FW: re application number 2024/70/91260/E

Ref planning application 2024/70/91260/E on Merchant Fields

status: PLANNING
 project: MERCHANTS FIELD CLECKHEATON
 site: SITE LAYOUT
 drawn: QYRB. date: MAY 2019
 checked: RB. scale: @ A0:1:500
 job no: 122. dsg no: 122-PL-01-V

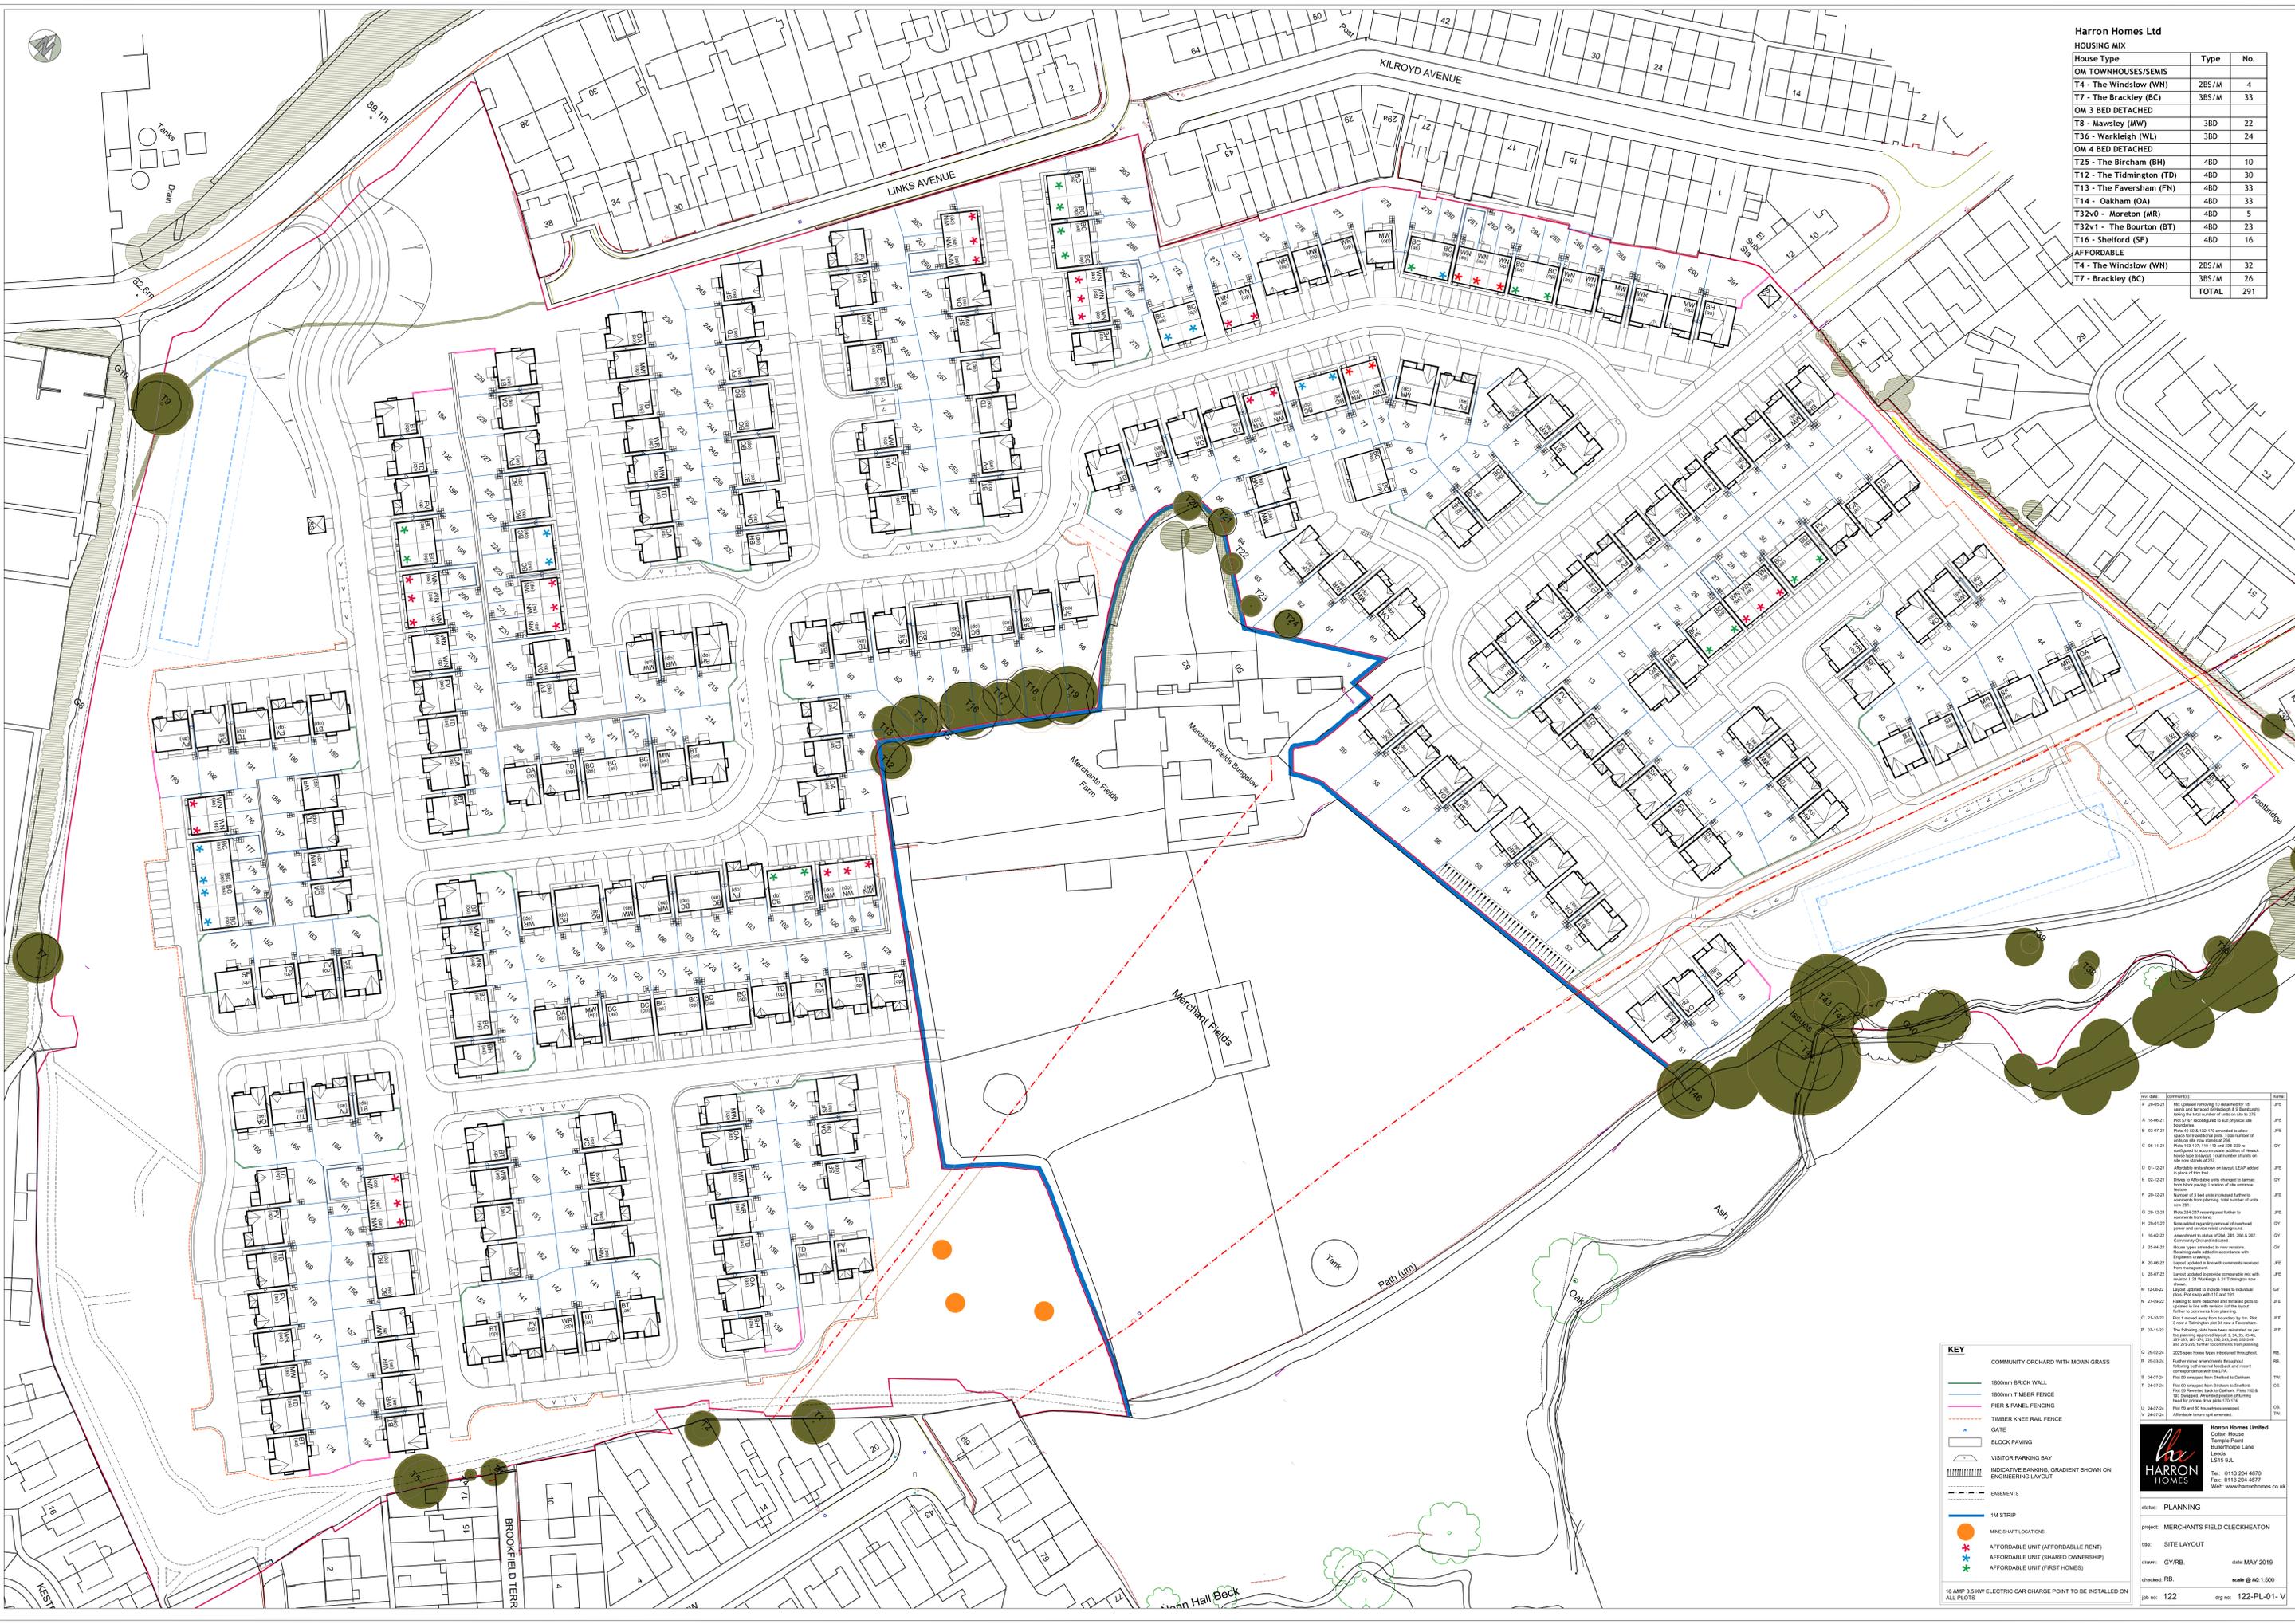
1. The road access detailed on the plans to and from site is clearly inadequate for both the construction phase and the ongoing habitation of the development. There are 2 proposed entry and exits onto already busy routes. These existing routes are often backed up at busy times and grid locked if there is an incident on the nearby M62, (which there often is). These surrounding roads are treacherous at times and there have been several fatalities on these roads.

10. There doesn't seem to be many open spaces/parkland, are the plans compliant with the specified amounts and suitability? There is a small area set aside but this is hilly and would be impractical for many outdoor pastimes, there are no centralised green/common areas. The area set out appears to be 'lip service' to the planning requirements.

11. The roads on the plan look narrow and as they are winding this could be a problem for parking for so many new residents. This also brings into question the access for emergency vehicles, the 2 access points to and from the site would be busy and congested, impeding emergency services access.
